601 CENTRAL AVE NE
+
501 CENTRAL AVE NE
RESPONSE TO SKETCH PLAT
COMMENTS

Integrated Design & Architecture
Meeting Date: March 20, 2024

REQUIRED SIDEWALK & LANDSCAPE BUFFER

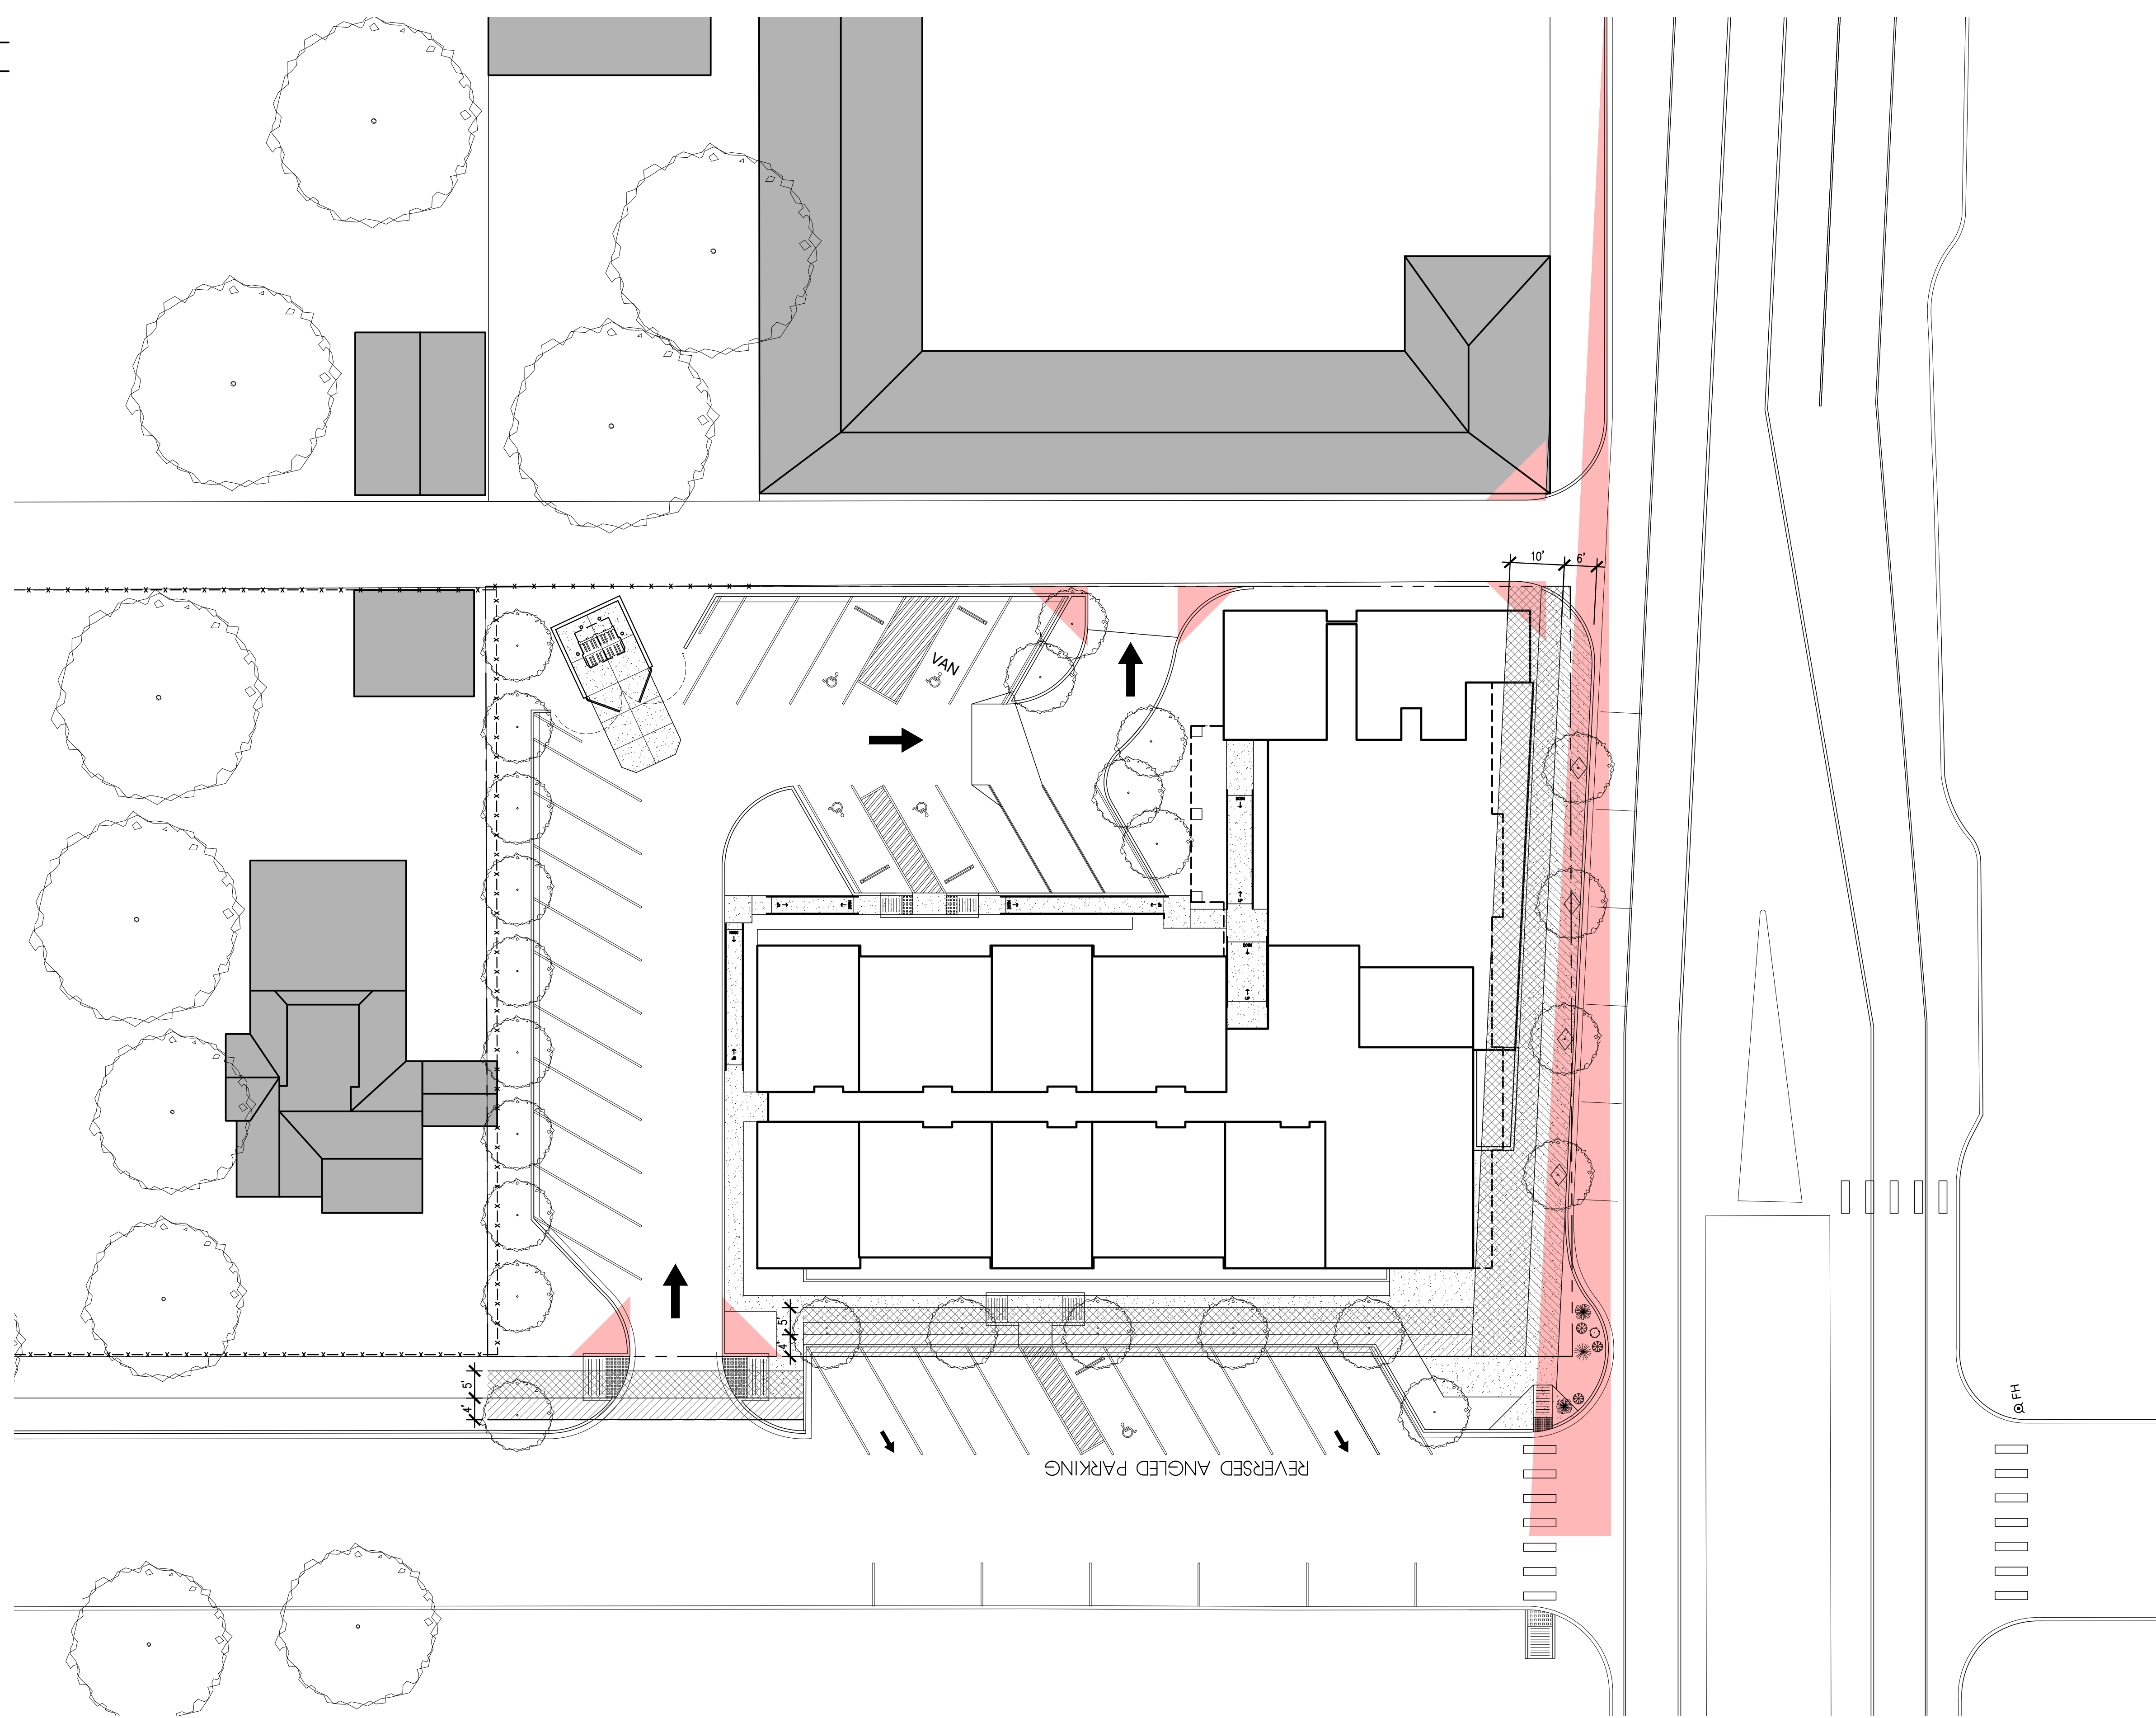
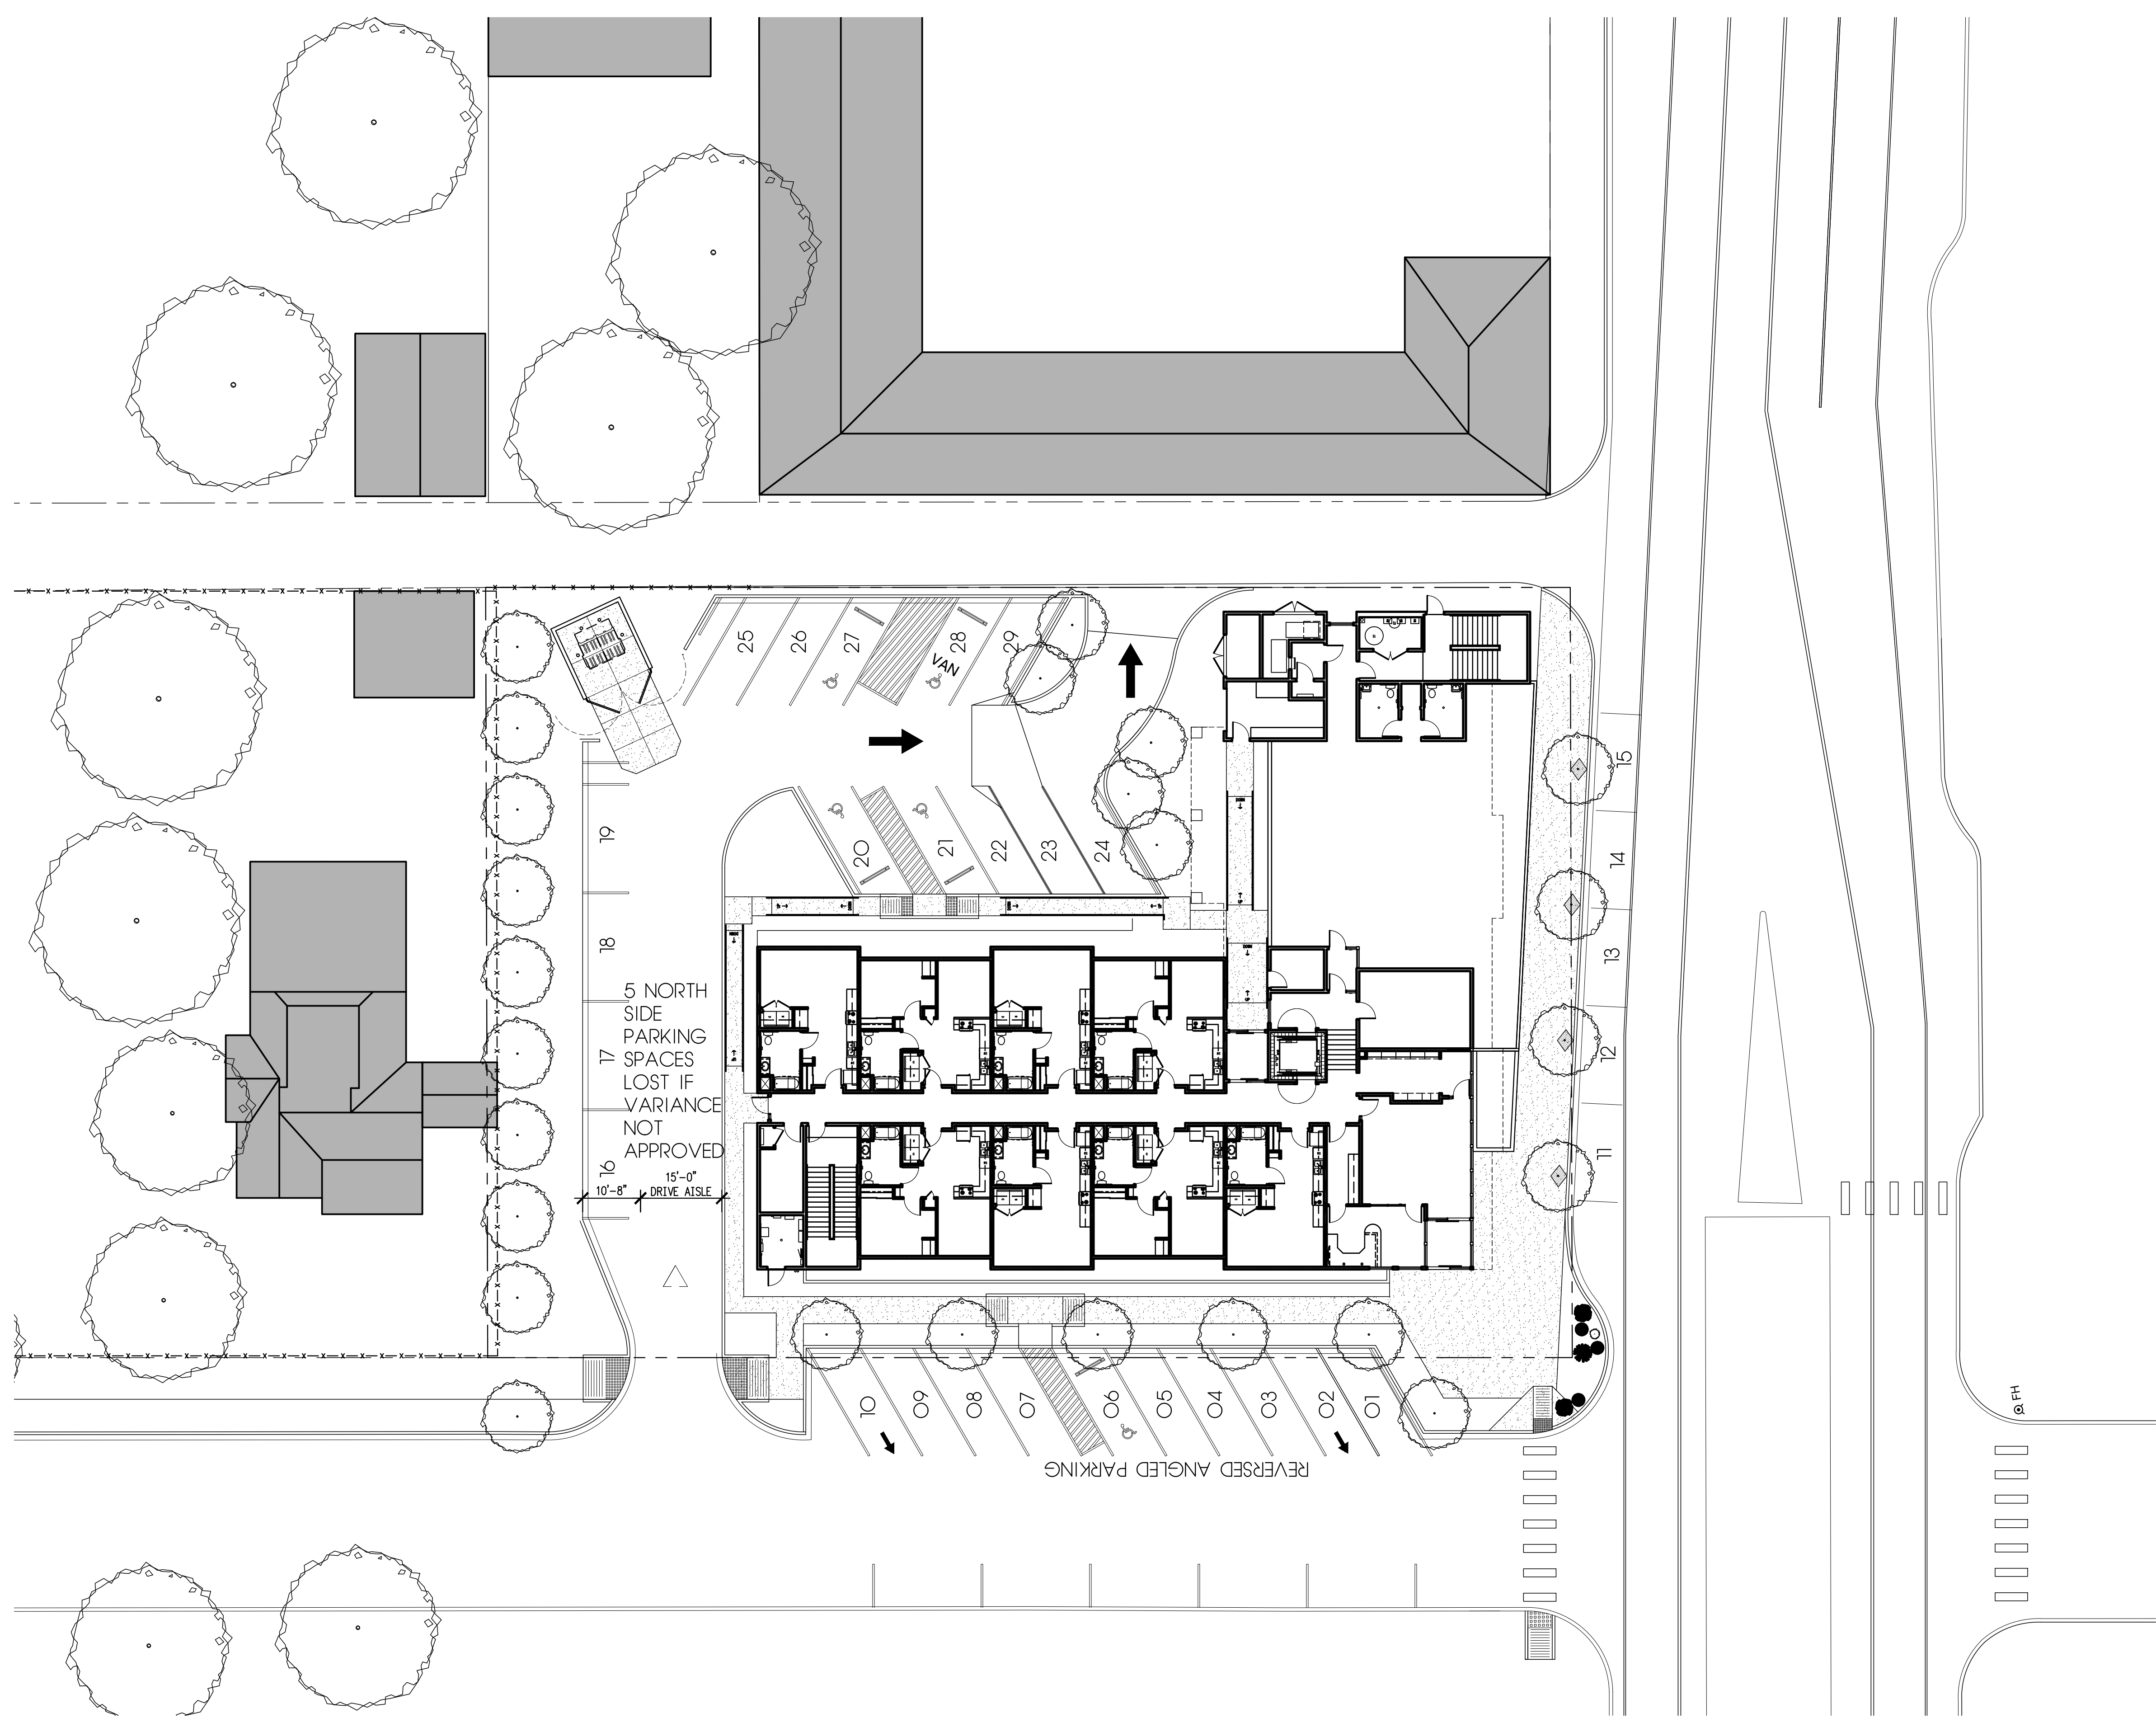
Sketch Plat Comments: None. This was a verbal mention of adding sight triangles to the site plan. There were comments about 50% of the building being along the property line starting at the corner and staying within the maximum 1 ft. setback: “This is located in the PT (Premium Transit) and MS (Main Street) area Building must start at the corner and be no more than 1 ft from the front property line as per the setbacks in CPO-4 14-16-3-4(E) and no more than 15 ft from the corner side yard.”

Discussion: Previous discussion (3/6/24): City mentioned we should show clear sight triangles on the site plan.

Question/Response: IDA has added clear sight triangles to the drawings, see reference below.

On the 601 site, the required trees along Central Avenue are in conflict with the clear sight triangle requirements. What requirement prevails?

Sketch Plat Comments: “Central is a Main Street Corridor and requires 10’ to 12’ sidewalks with 6’ to 8’ landscape buffer. Walter is a local road and requires 5’ sidewalk with 4’ to 6’ landscape buffer.”

Discussion: Previous discussion (3/6/24): Ernest mentioned that he understands that the landscape buffer and sidewalk width may not fit on the site and that they are open to waiving that requirement. IDA mentioned that none of the other nearby sites seem to have a landscape buffer and neither does the new hotel that was just built in the last few years on Central.

Question/Response: IDA has put together a diagram for both sites that shows how the required DPM sidewalk and landscape buffer width, if provided, would cut into the building making us lose necessary square footage. We would like to confirm that we can go after a waiver with the transportation department and that it is not a variance through planning?
